Urban Design Observations		Officer:		Stephen Kilmartin	
Description:	Land off Waddington Road, Clitheroe			 Ribble Valley Borough Council www.ribblevalley.gov.uk	
Application Ref:	2018/0181	Case Officer:	S.K		
Response Ref:	2018/0181/UD/03	Issue Date:	04/12/18

General Observations:	
1.1	The following observations are in relation to Preliminary layout drawing DWH063 – PL01 Rev: P4 received on the 23 rd of November 2018.

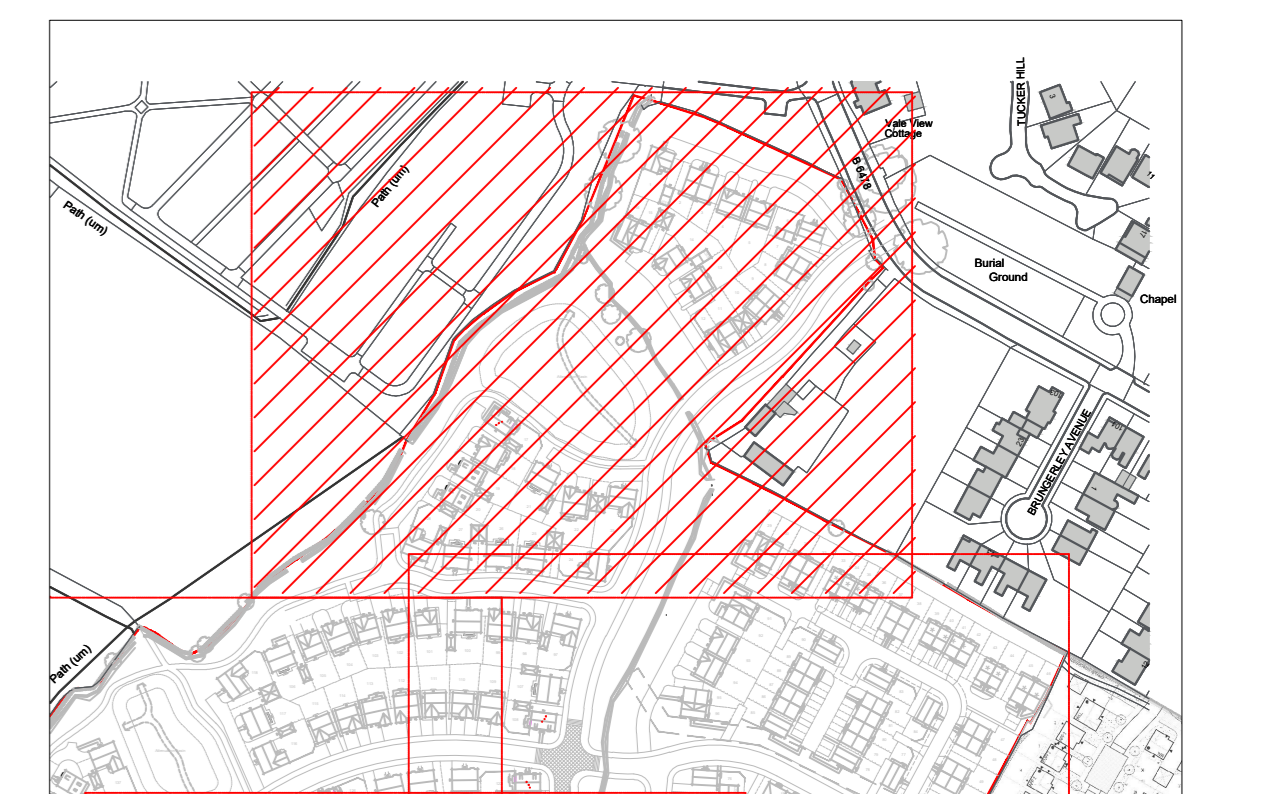
- 3.4** I note the inclusion of the 10m buffer around the periphery of the development site. A full planting schedule will be required in respect of the proposed landscaping of this margin. I would expect such a schedule to include a significant amount of native species tree and hedgerow/shrub planting. **(Matter outstanding)**

- 3.6** I am disappointed that the peripheral circular pedestrian route (within the green margin) appears to have been omitted from the proposal. I would consider that this should be reintroduced to allow for opportunities for residents and the wider community to engage with the green infrastructure to be brought forward as part of the proposal. I would also request you explore the potential for the inclusion of trim trail equipment in these areas. Please refer to my previous observations in relation to arrangements/points of connectivity. **(Matter not addressed/outstanding)** [\(Please see attached annotated layout\)](#)

Playspace Layout  
David Wilson Homes North West

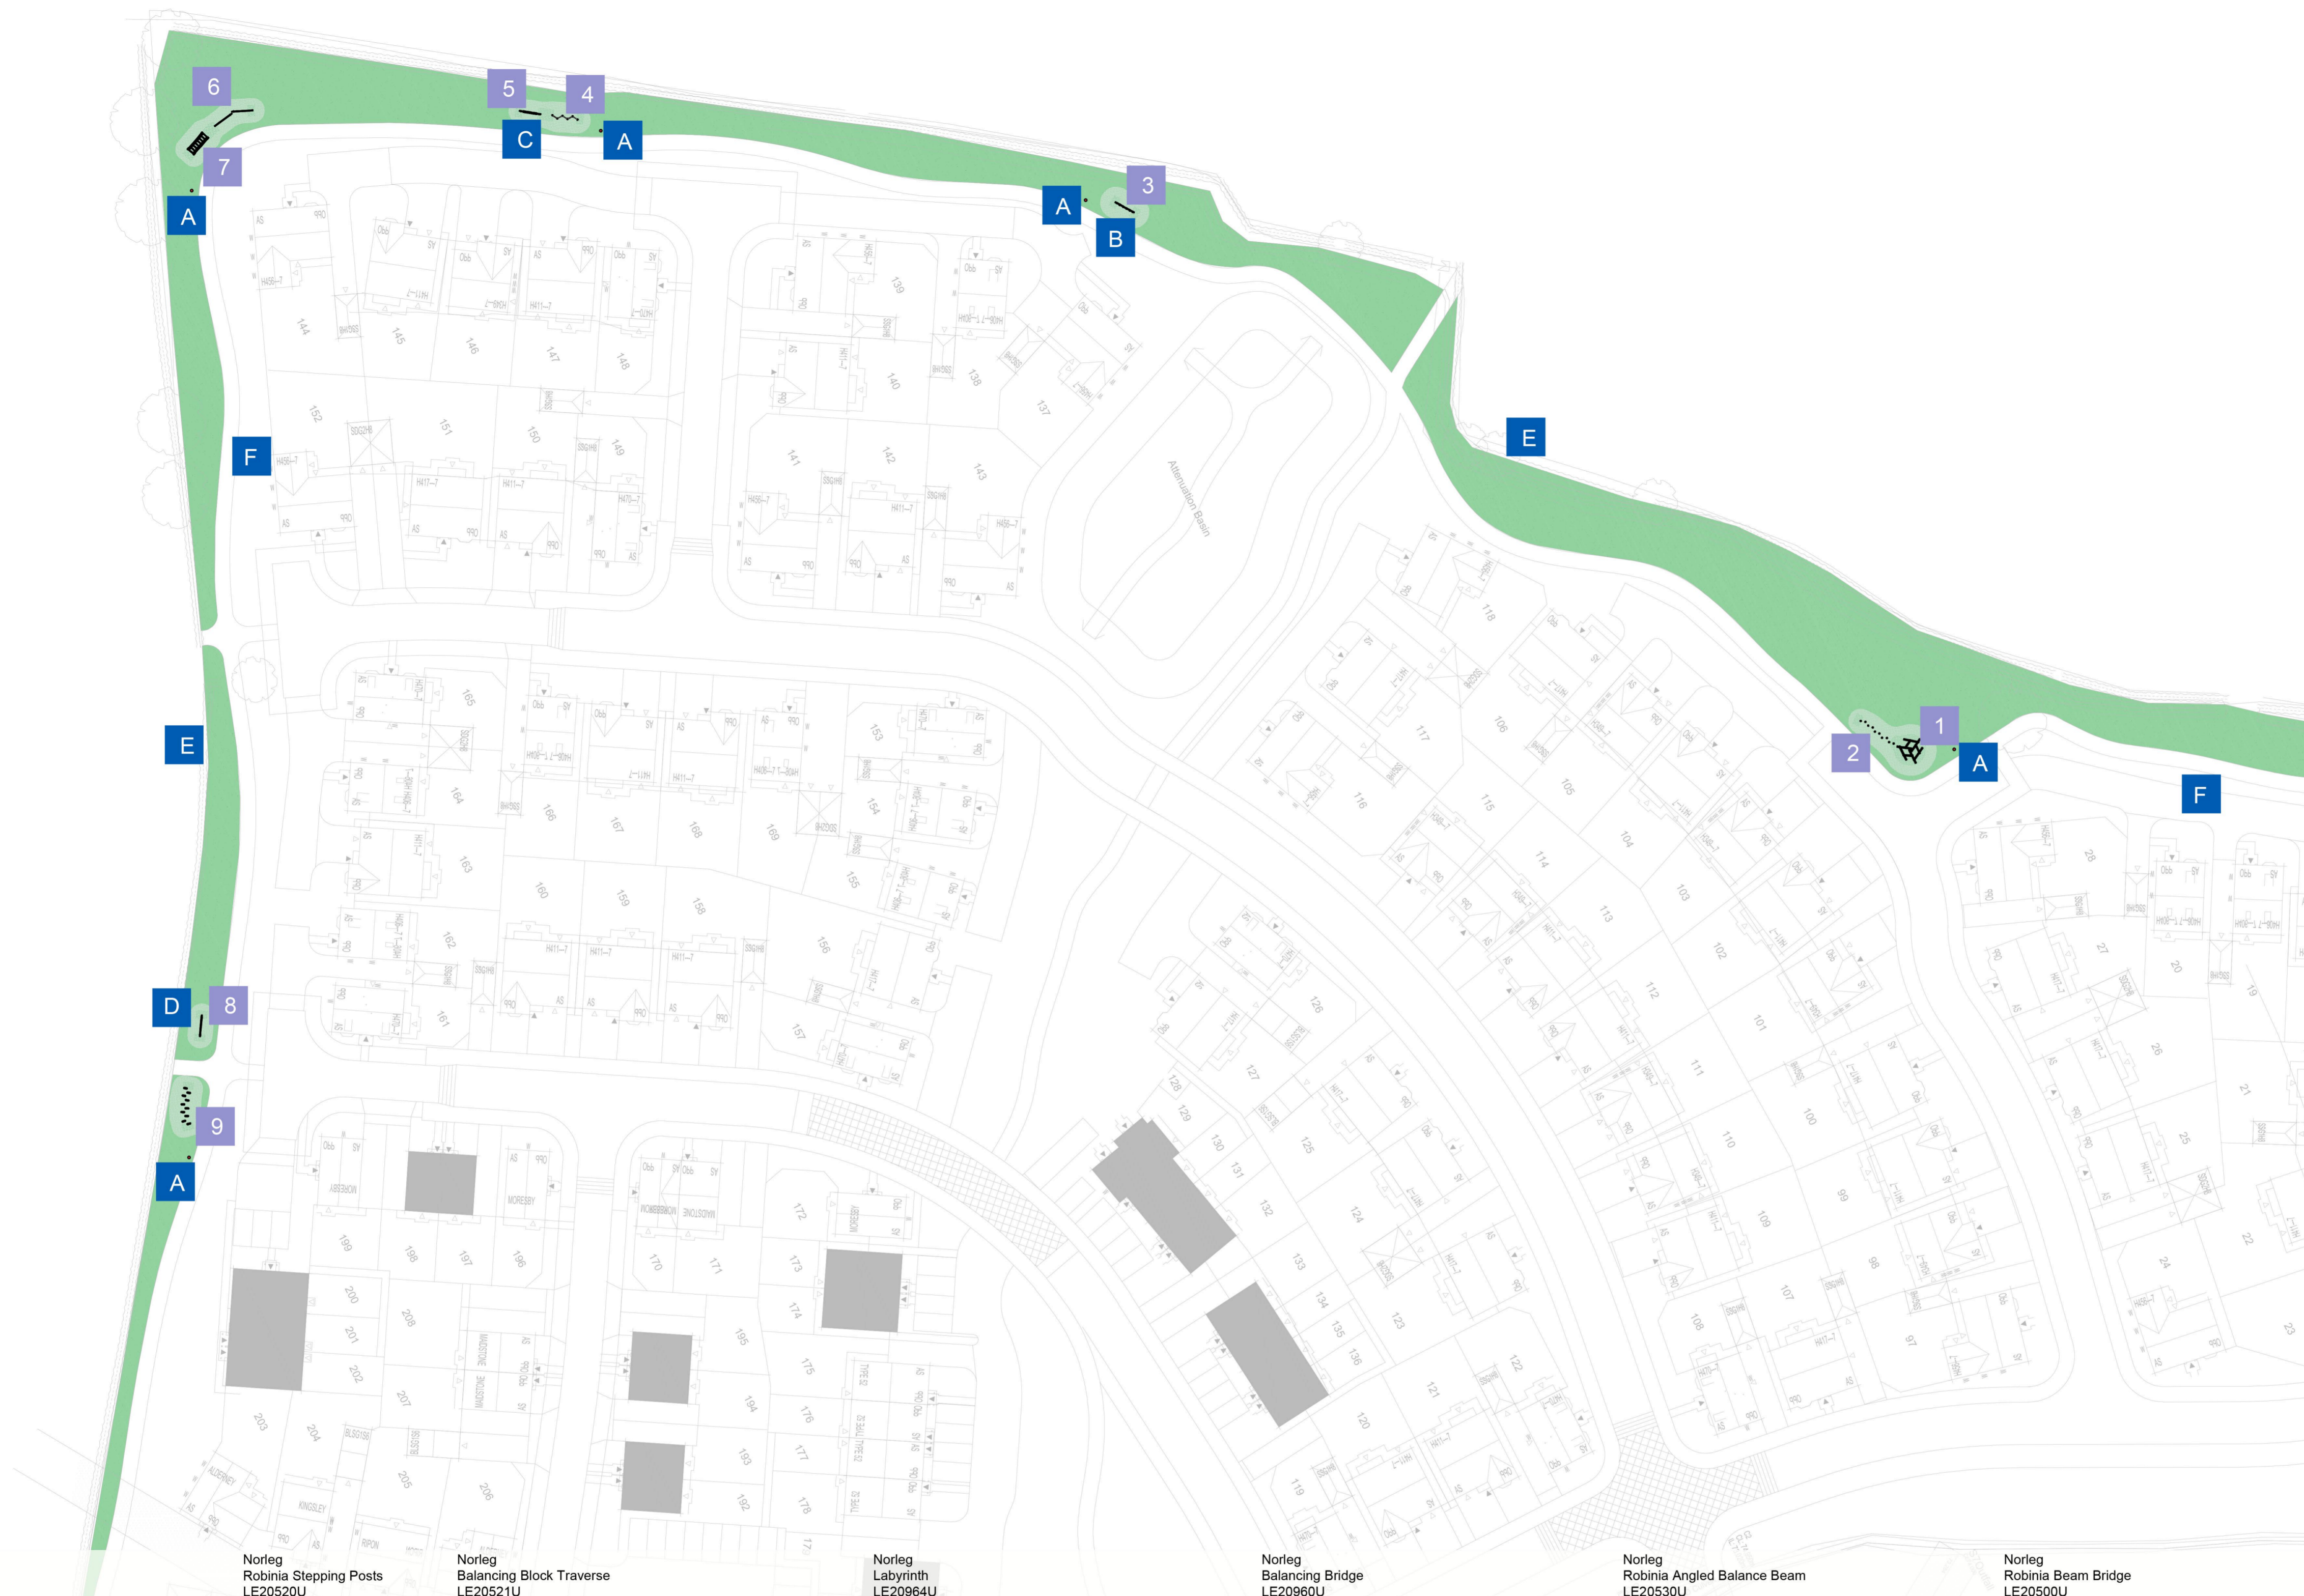
- 3.5** I note that the submitted sketch layout does not appear to provide any dedicated provision for usable open space. You will note that providing such provision is a requirement not only of the outline consent but also a requirement of Policy DMB4 of the Adopted Core Strategy. The LPA will be unable to support the proposal where there is a fundamental failure to provide adequate on-site usable open space. **(Matter outstanding)**

Drawing Title
SECTIONS THROUGH EXISTING PROPERTIES

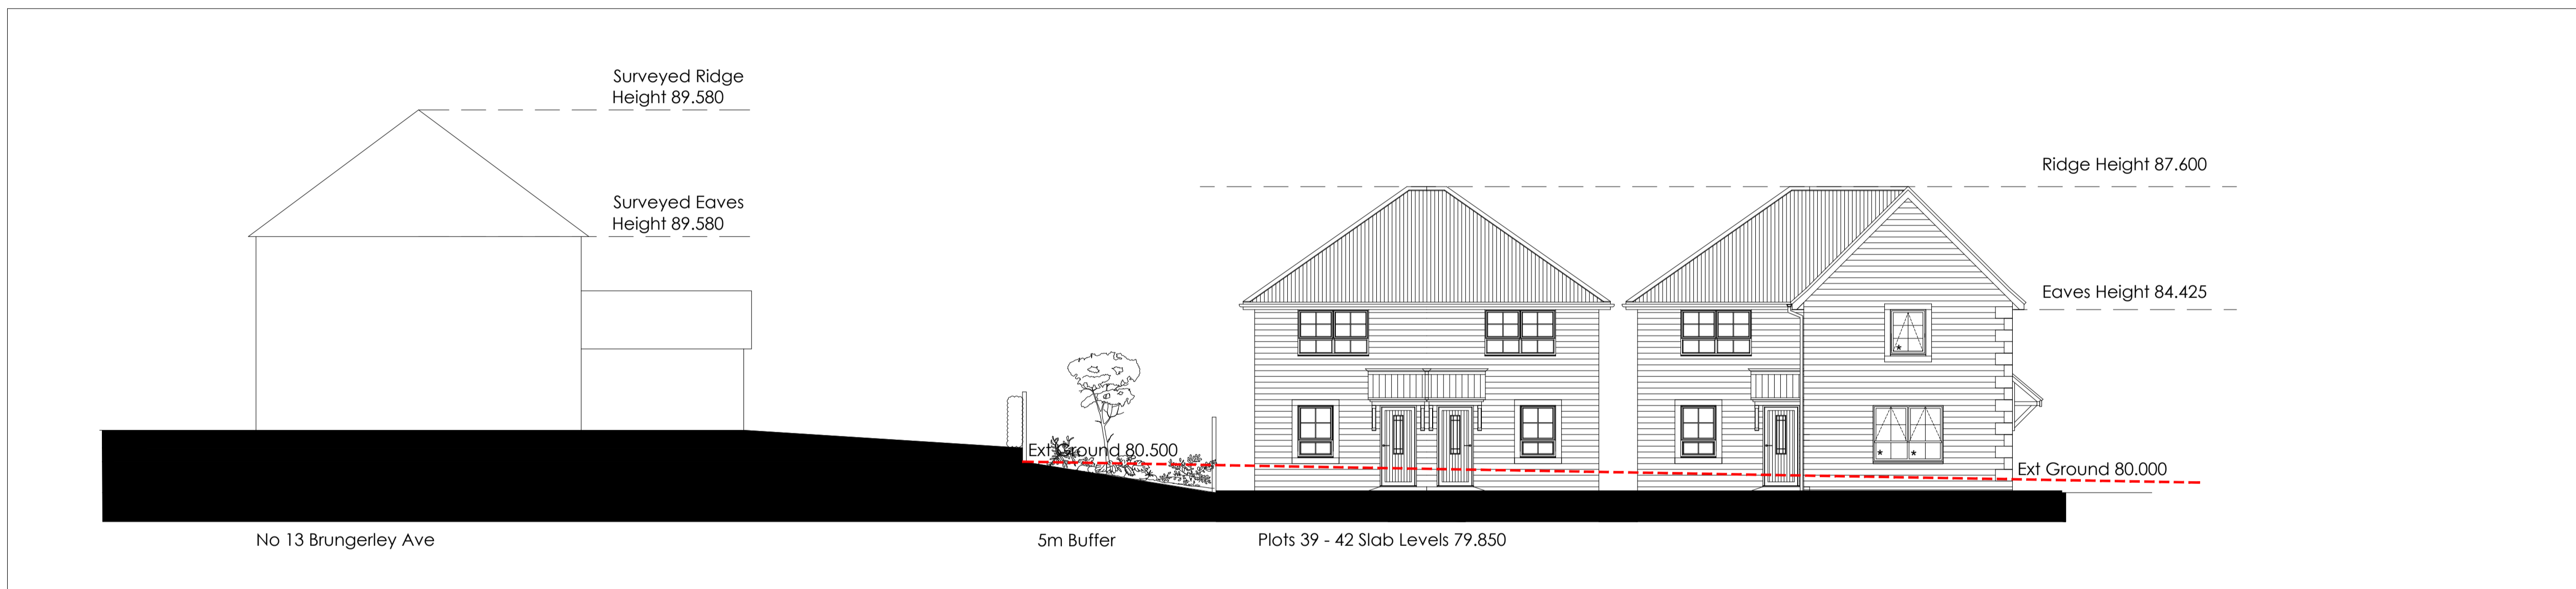
- 2.1** The revised layout appears to result in a number of plots being located less than 21m from the adjacent properties on Brungerley Avenue. It would also appear your layout fails to take account of additions/extensions that have been undertaken to the aforementioned properties. The authority will not support any proposal where the 21m interface distance standard is not met.

- 2.6** There are a number of plots that still fail to meet the 21m offset/interface distance. Please note the authority will not support any proposal where this standard is not met. I would also be obliged if you could dimension rear to rear interface distances on any revised layout plan.
